SSD 77020757 – OAKDALE EAST PRECINT 2 – ENVIRONMENTAL IMPACT STATEMENT – FAIRFIELD COUNCIL SUBMISSION

This letter responds to the RTS prepared by Goodman associated with the EIS for Precinct 2 of the Oakdale East Industrial Estate. Council has reviewed the RTS document prepared by the Applicant and attached supporting documentation and provides the following comments.

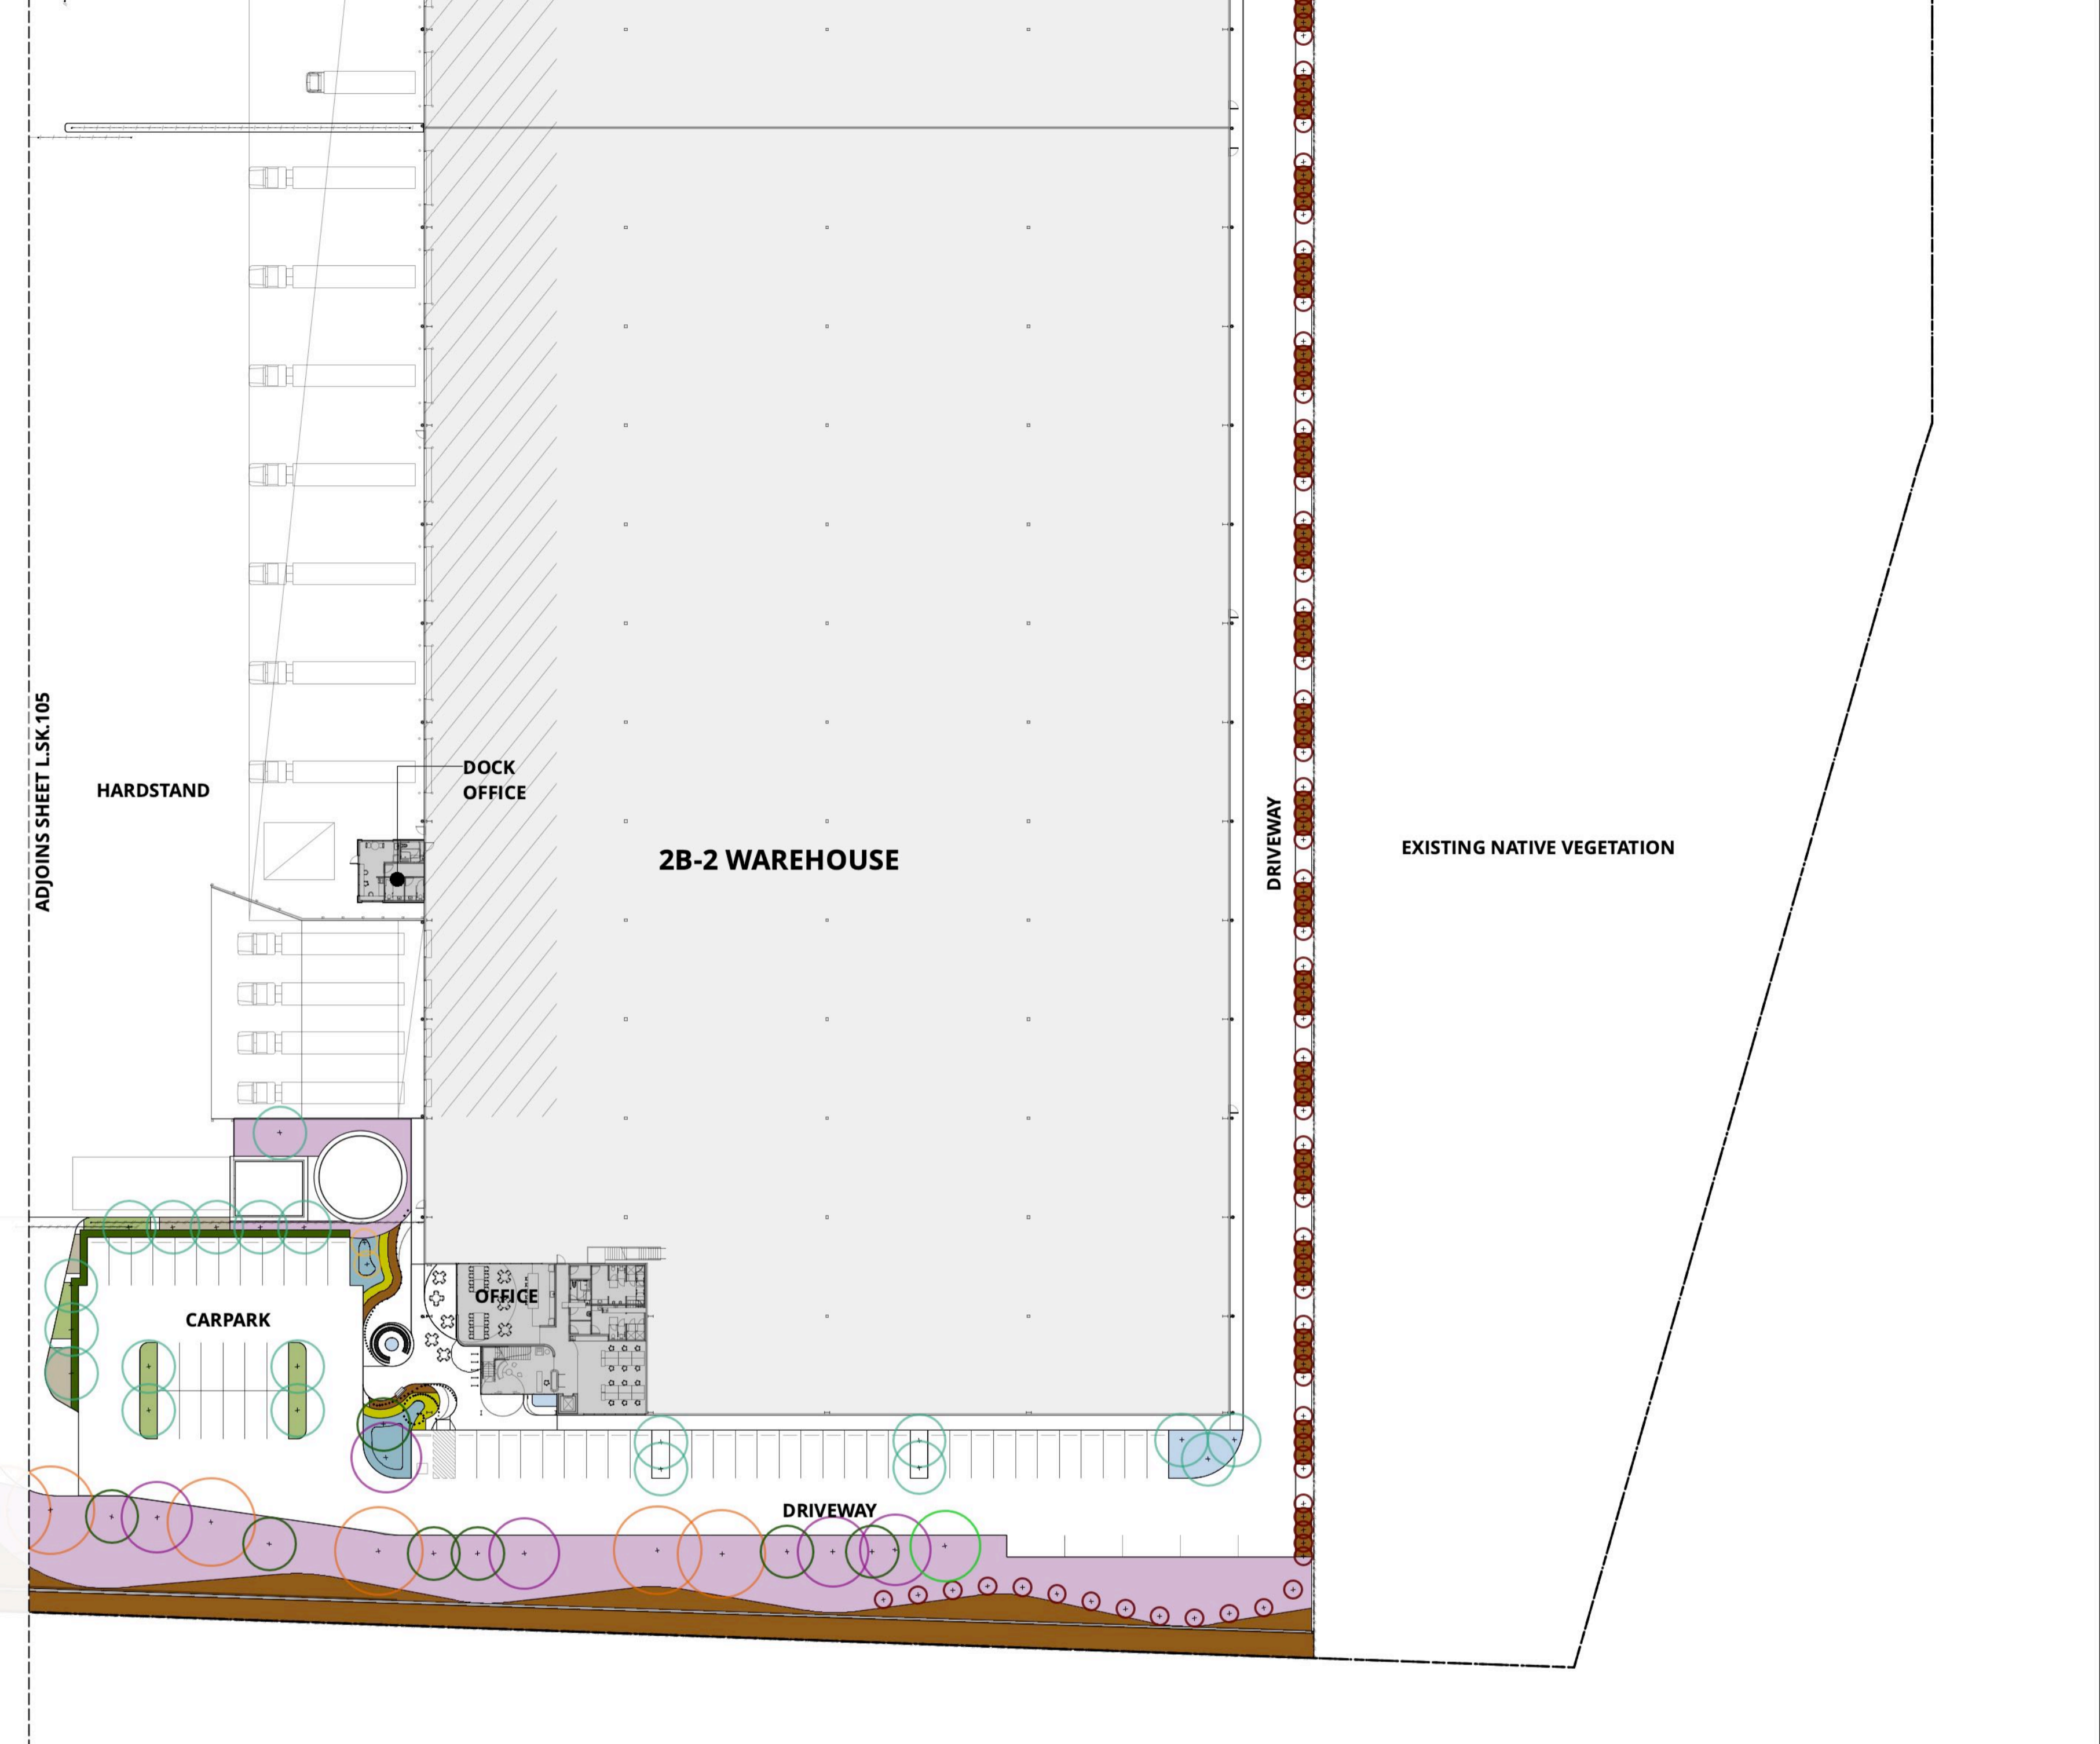
1. Landscape Plans – In the adopted Fairfield Biodiversity Strategy, Part 3 Section 4.3, it is recommended that within 100m of remnant bushland hybrid species should not be planted. Due to the proximity of the managed ecological zone that has a Vegetation Management Plan for its continual management, no hybrids are supported. Plant species selection for this modification need to be made from the Cumberland Plain plant community as found on Council's webpage [2018_cumberland_plain_woodland_education.pdf \(nsw.gov.au\)](https://www.nsw.gov.au/2018_cumberland_plain_woodland_education.pdf). an extract provided below from Council's Biodiversity Strategy shows Council's requirements:

However, a revised landscape plan is to be submitted in line with Council's Biodiversity Strategy and recommendations on species listings above. Should you have any further

- *Invasiveness: including native species that can be invasive e.g., avoid or limit planting of Mount Morgan Wattle, Cootamundra Wattle, Callistemon viminalis etc in proximity to waterways or natural areas.*

- *Possible genetic hybridisation with similar native species, otherwise known as genetic pollution e.g., avoid nursery hybrids of threatened species that occur in the Greater Sydney Bioregion, such as Syzygium paniculatum and Grevillea juniperina.*

- *Proximity to nearby or adjacent natural bushland areas e.g., ensure nursery hybrids of locally occurring native species are not planted within 100 m of natural areas.*

- *Only local provenance plant stock should be planted in or adjacent to reserves, to complement existing vegetation. Provenance of plants to be of the Greater Sydney Bioregion plant species specific to Fairfield City Council LGA.”*
